From: Laura Gibbons
Sent: 15 March 2019 12:14
To: Planning.Responses
Cc: Simon Davis
Subject: RE: Planning Consultation on FP/42/19/DOC

Engineers Comments Regarding Condition 7

APPLICATION **FP/42/19/DOC**

Description of Works: Approval of details reserved by condition imposed under ref
FP/171/18/PL relating to Condition Nos
5,6,7,8,9,10,11,12,13,14 & 24.

NB: Sub-base construction depths are shown as minimum construction requirements. Specific construction depths vary, e.g. where sub-base falls (to collection point) in opposite direction to surface falls. See respective Drainage Layout for specific sub-base levels.

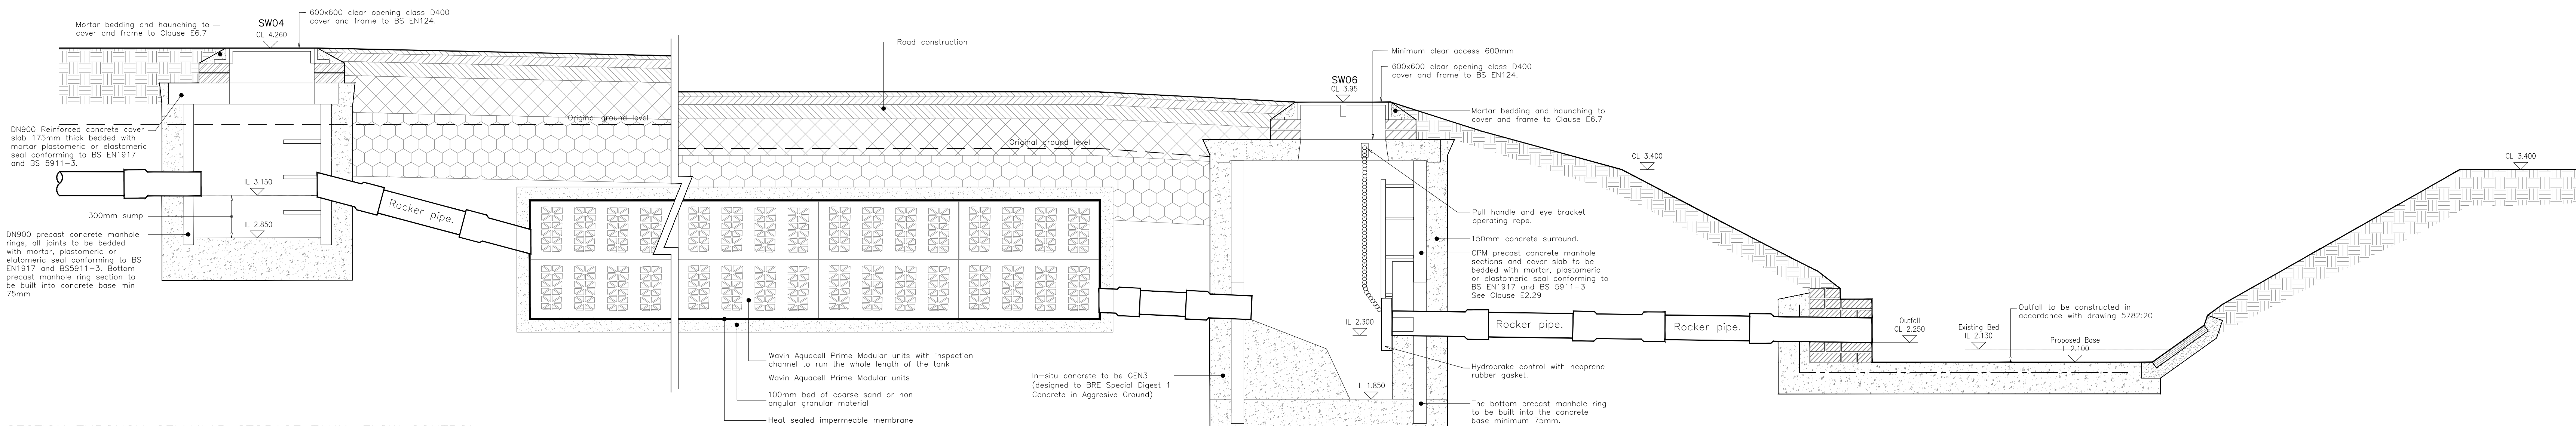
1. Catchpits must be provided upstream of all connections into the attenuation tank.
2. No construction detail drawings have been provided. Please provide construction detail drawings of manholes, catchpits, permeable paving, attenuation tank and hydrobrake.
3. There is conflict between the landscaping proposals and the drainage proposals. Trees must not be located on or near attenuation tanks. Please revise the landscaping proposals.
